**KIRKLEES METROPOLITAN COUNCIL
INVESTMENT & REGENERATION SERVICE**

DELEGATED DECISION TO DETERMINE PLANNING APPLICATIONS

Reference No:	2026/62/91350/E
Site Address:	4, Thornville Mount, Scout Hill, Dewsbury, WF13 3RS
Description:	Erection of front porch (retrospective)
Recommending Officer:	Jennifer Booth

PROPOSED FRONT ELEVATION

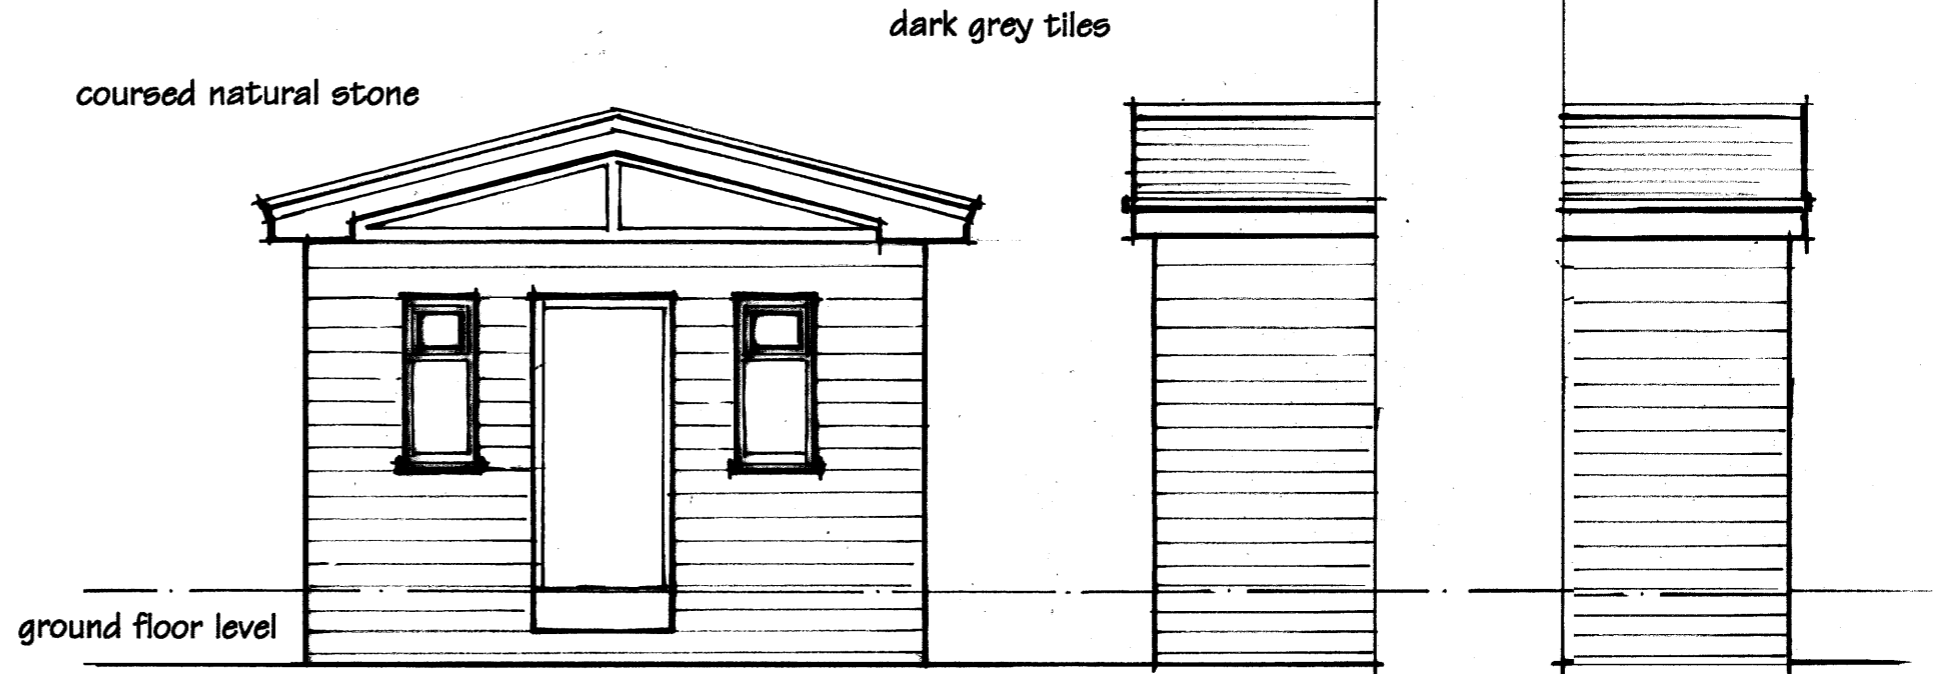
Due to the scale and design, the front extension would result in an overly dominant form of development. It occupies the full width of the property's frontage thereby significantly altering the simple and uniform appearance of the terraced dwelling. By reason of its scale, massing and design, the extension fails to reflect the modest proportions and architectural character of the host property or the wider terrace. The development would appear visually prominent and incongruous within the street scene, disrupting the established

The front extension, by virtue of its scale, width and design, would occupy the full frontage of the property and fail to respect the simple form, proportions and architectural character of the host terraced dwelling. The development would appear overly prominent and incongruous within the street scene, disrupting the established rhythm and visual cohesion of the terrace and causing harm to the character and appearance of the area. The proposal is therefore contrary to Policy LP24 of the Kirklees Local Plan, KDP1 & KDP2 of the House Extensions & Alterations SPD and Chapter 12 of the National Planning Policy Framework.

1. The front extension, by virtue of its scale, width and design, would occupy the full frontage of the property and fail to respect the simple form, proportions and architectural character of the host terraced dwelling. The development would appear prominent and incongruous within the street scene, disrupting the established rhythm and visual cohesion of the terrace and causing harm to the character and appearance of the area. The proposal is therefore contrary to Policy LP24 of the Kirklees Local Plan, KDP1 & KDP2 of the House Extensions & Alterations SPD and Chapter 12 of the National Planning Policy Framework.
